Norfolk Boreas Offshore Wind Farm

Appendix 19.1

Norfolk Vanguard Ground Conditions and Contamination Consultation Responses

Applicant: Norfolk Boreas Limited
Document Reference: 6.3.19.1
RHDHV Reference: PB5640-006-1901
Pursuant to APFP Regulation: 5(2)(a)

Title:  
Minerals safeguarding areas  
(Map 1 of 9)

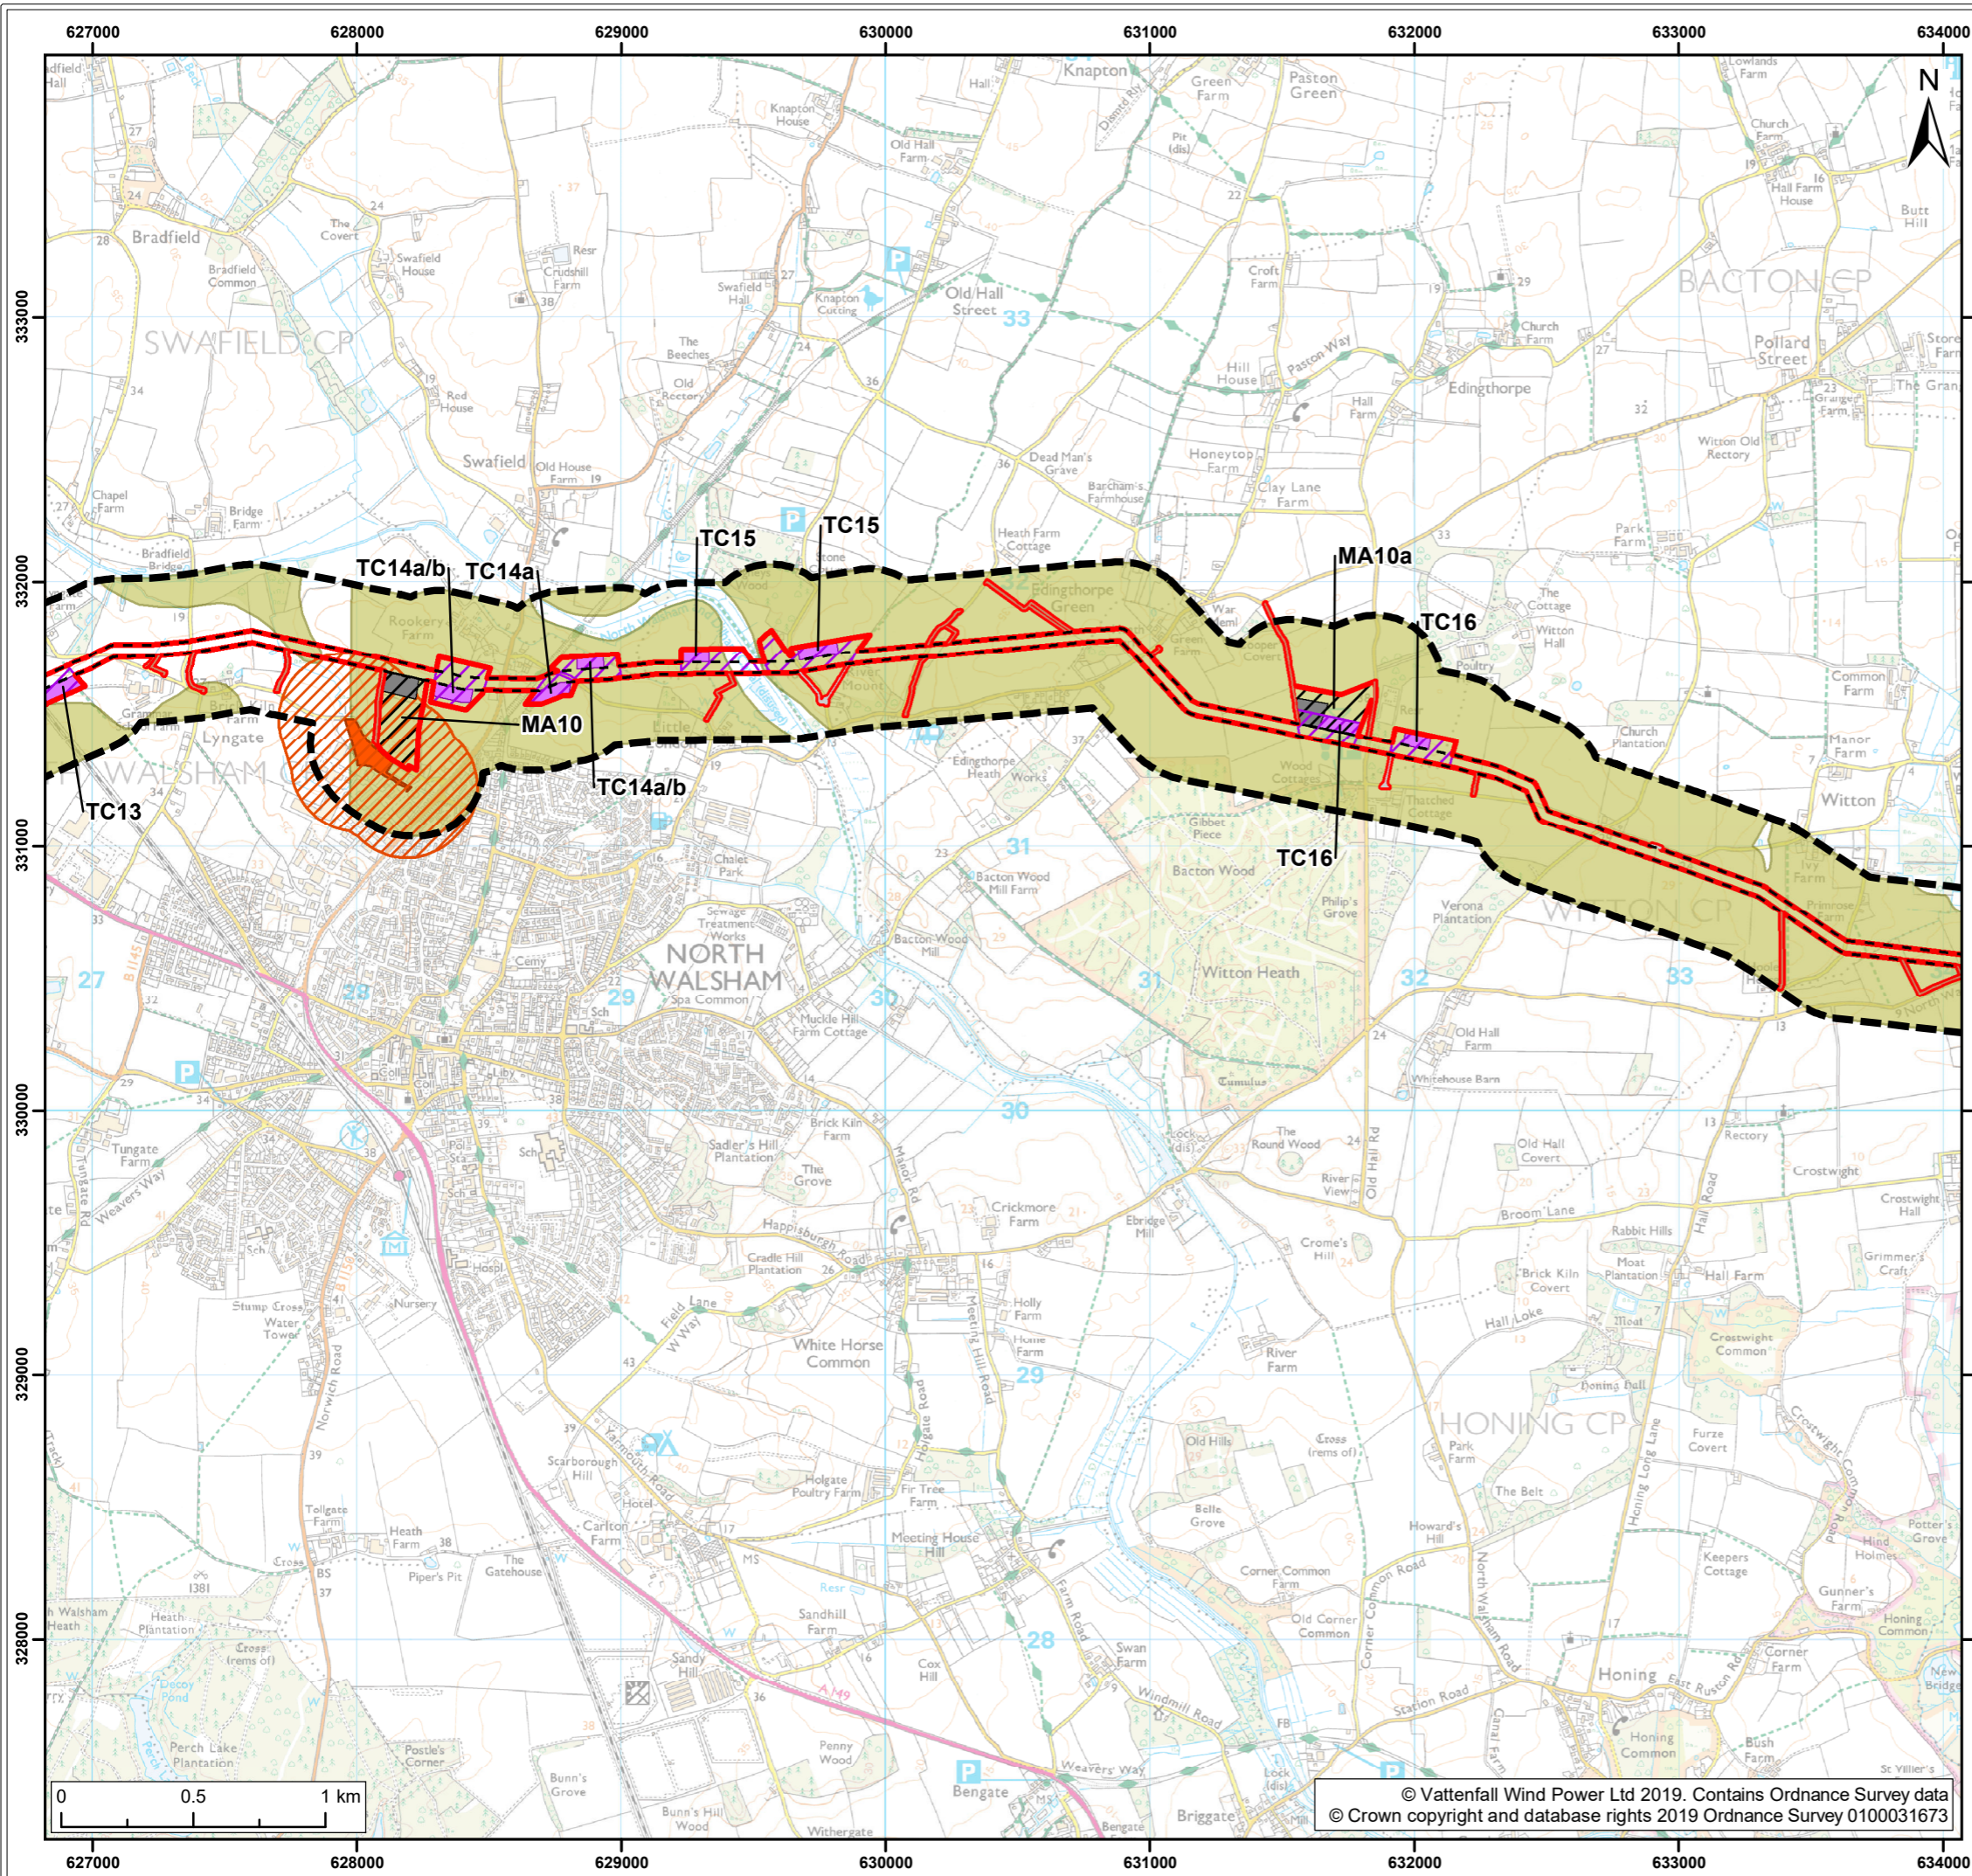
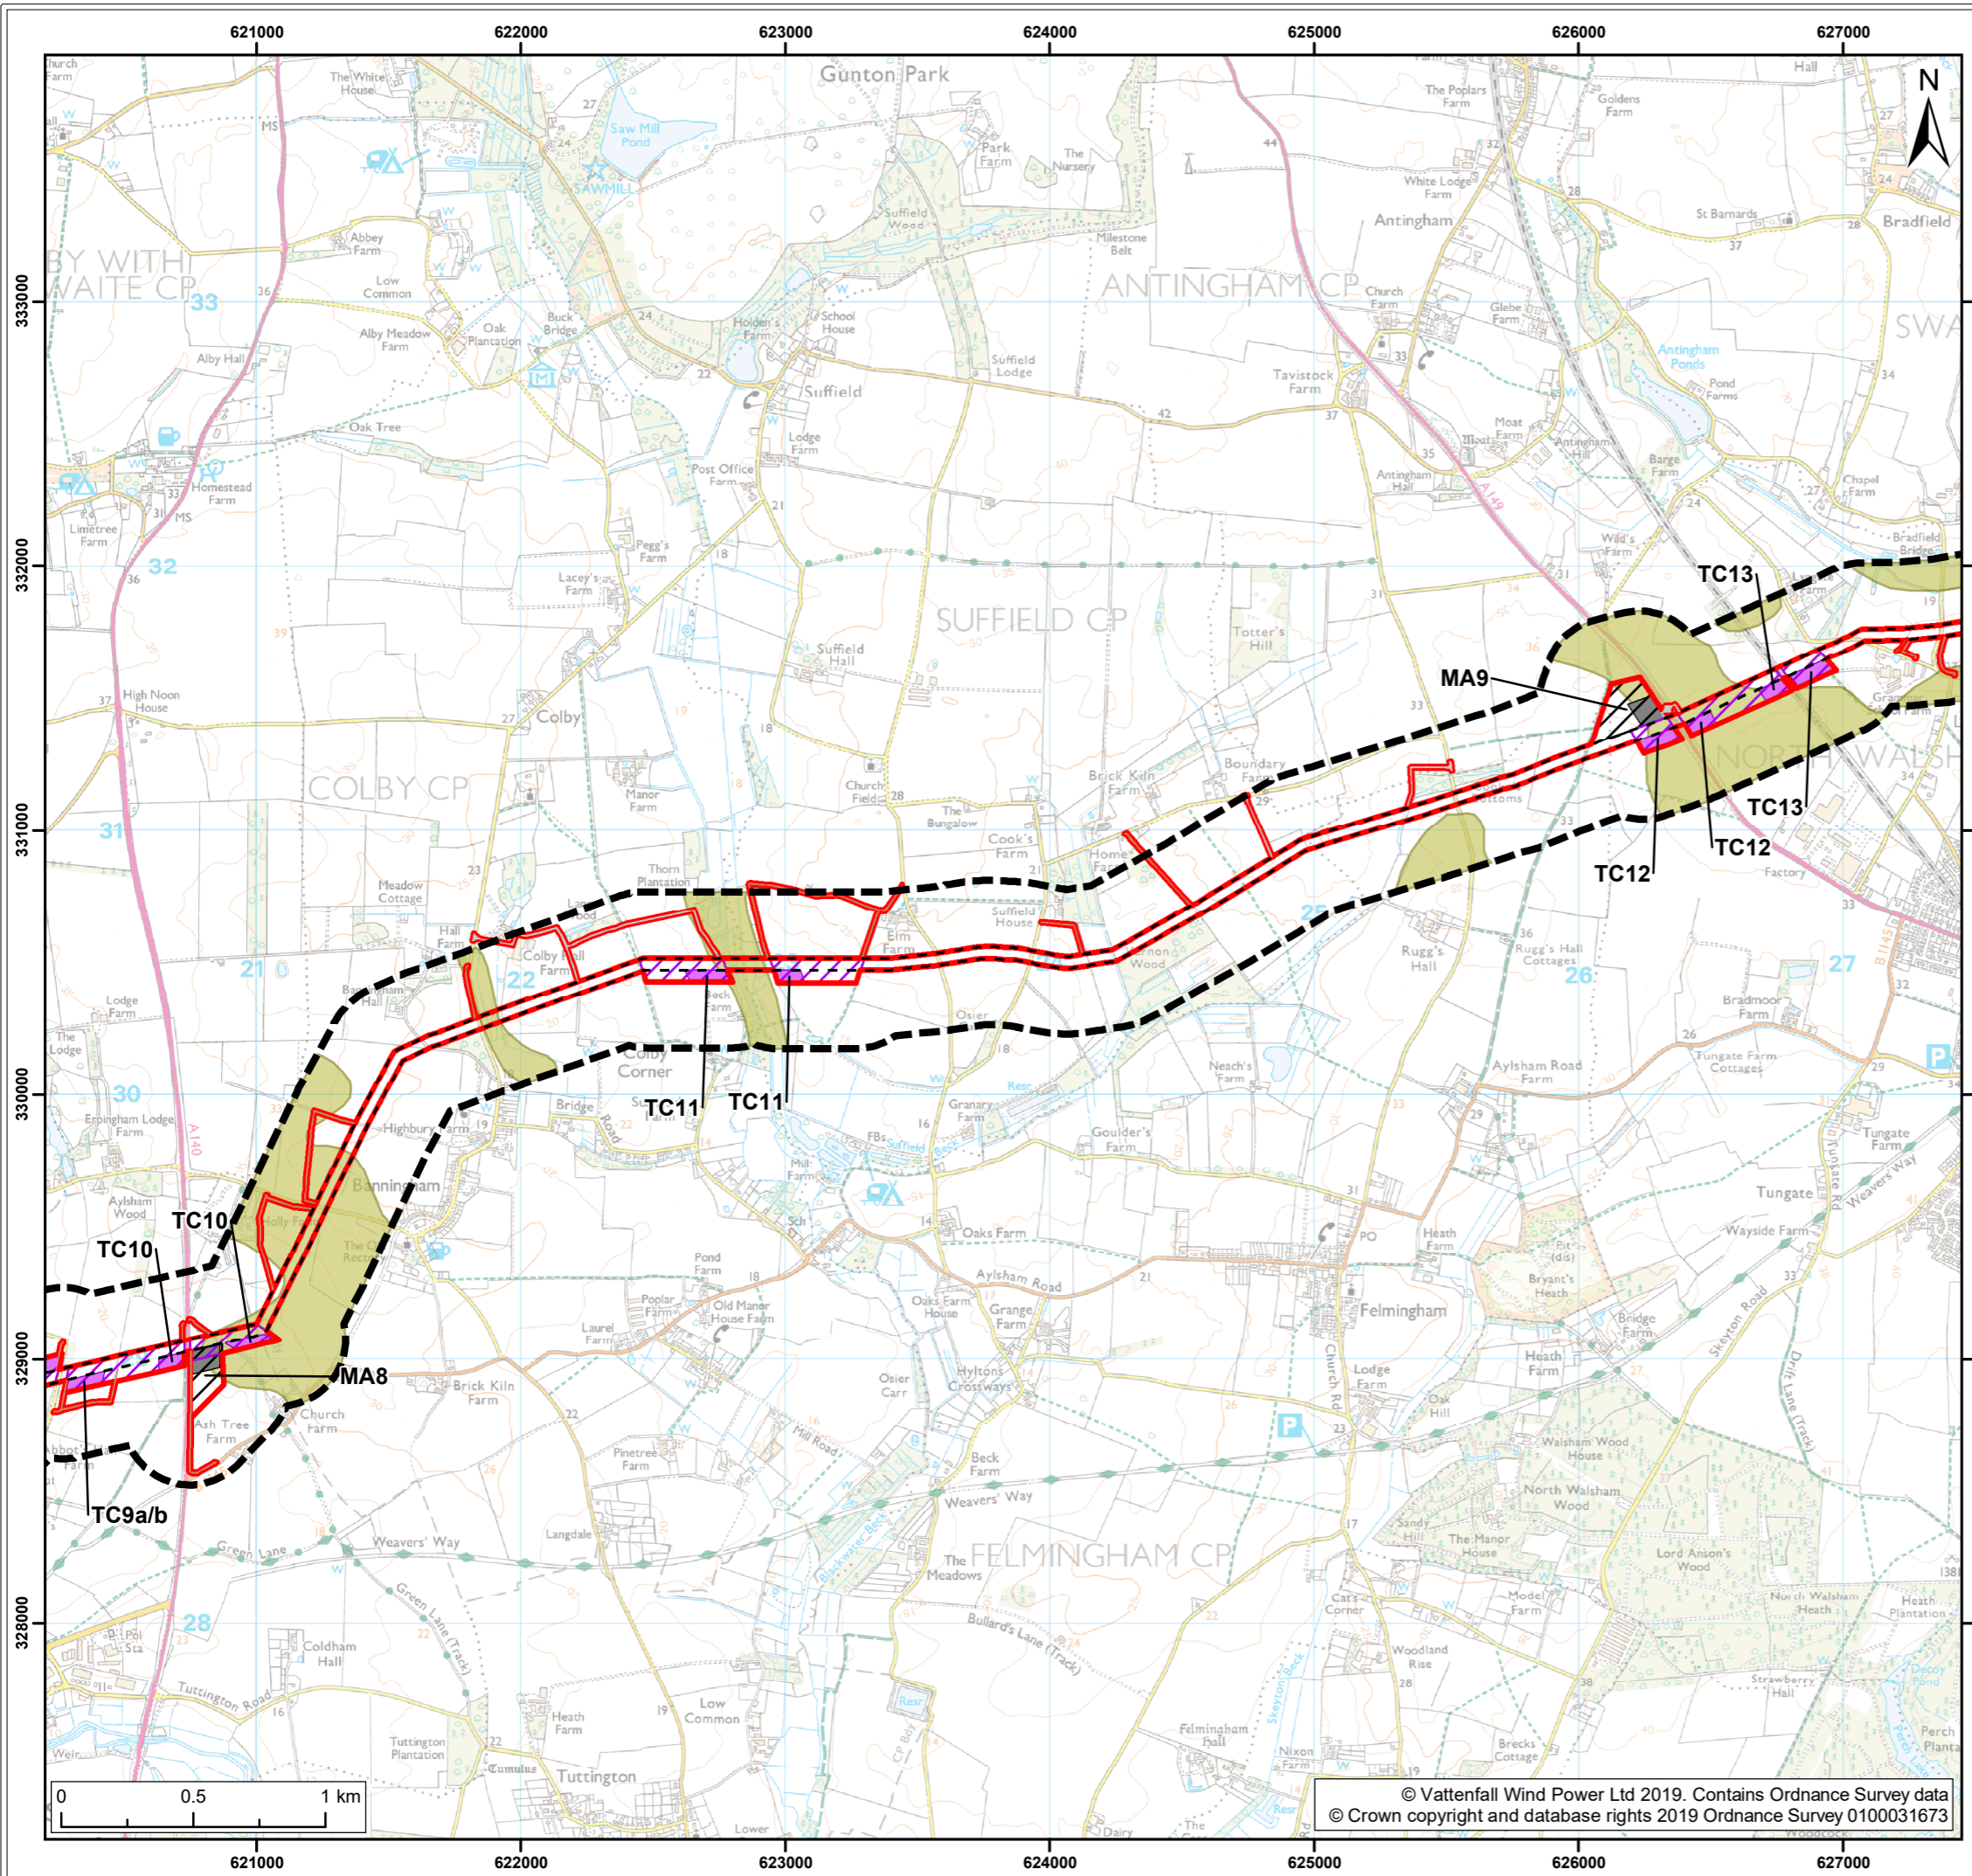
Consultee	Date /Document	Comment	Response / where addressed in the Norfolk Boreas ES Chapter 19
Secretary of State (SoS)	11 th November 2016 Scoping Opinion	The ES [Environmental Statement] should identify and assess potential impacts on the Mineral Safeguarding Areas underlying the onshore scoping area (see the comments of Norfolk County in Appendix 3 of this Opinion).	Mineral safeguarding data has been shared by Norfolk County Council and is considered within the assessment in sections 19.2 and 19.7.4.7.
SoS	11 th November 2016 Scoping Opinion	Paragraph 304 of the Scoping Report notes there is rapid cliff erosion on the coast of north east Norfolk. The potential impacts of landfall works on coastal processes, including erosion and deposition, should be addressed with appropriate cross reference to other technical reports including landscape and visual impacts. Reference should be made to the Kelling to Lowestoft Ness Shoreline Management Plan, where appropriate.	Rapid cliff erosion on the coast of north east Norfolk is considered within the assessment in sections 19.6 and 19.7.4.1. Appendix 4.5 Coastal Erosion Study of Chapter 4 Site Selection and Assessment of Alternatives also provides information in relation to coastal erosion.
